June 28, 2021

G-5244

Subject: Geotechnical Review of Project Construction Plans, New Residence,  
5401 West Mercer Way, Mercer Island, Washington

Typical Site Retaining Wall at Level Grade 4

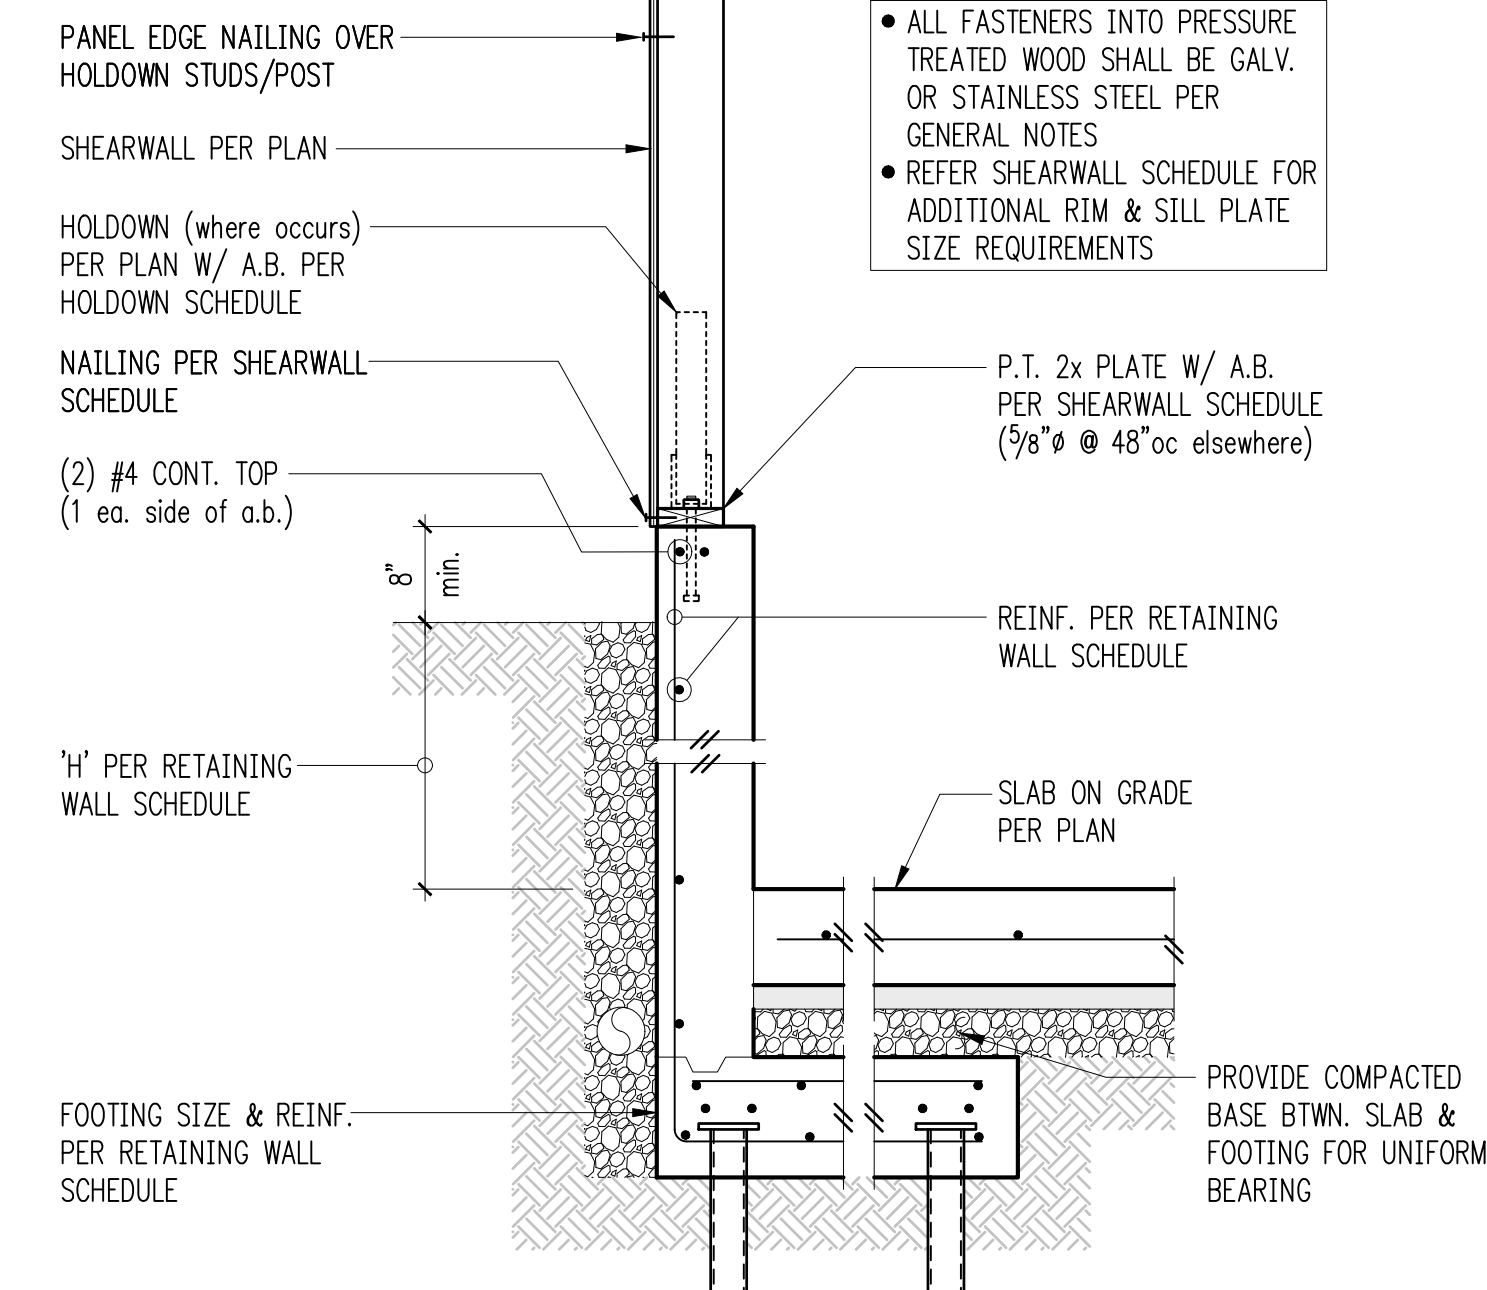
In our opinion, the use of weep holes to provide drainage for the exterior retaining walls located west of the new house is acceptable from a geotechnical perspective. We recommend that the weep holes have a minimum diameter of 2 inches and a lateral spacing of not more than 6 feet on-center. A zone of free-draining material that has a minimum thickness (i.e., width) of 12 inches should be placed against the back of these walls to provide for distribution of drainage water to the set of weep holes.
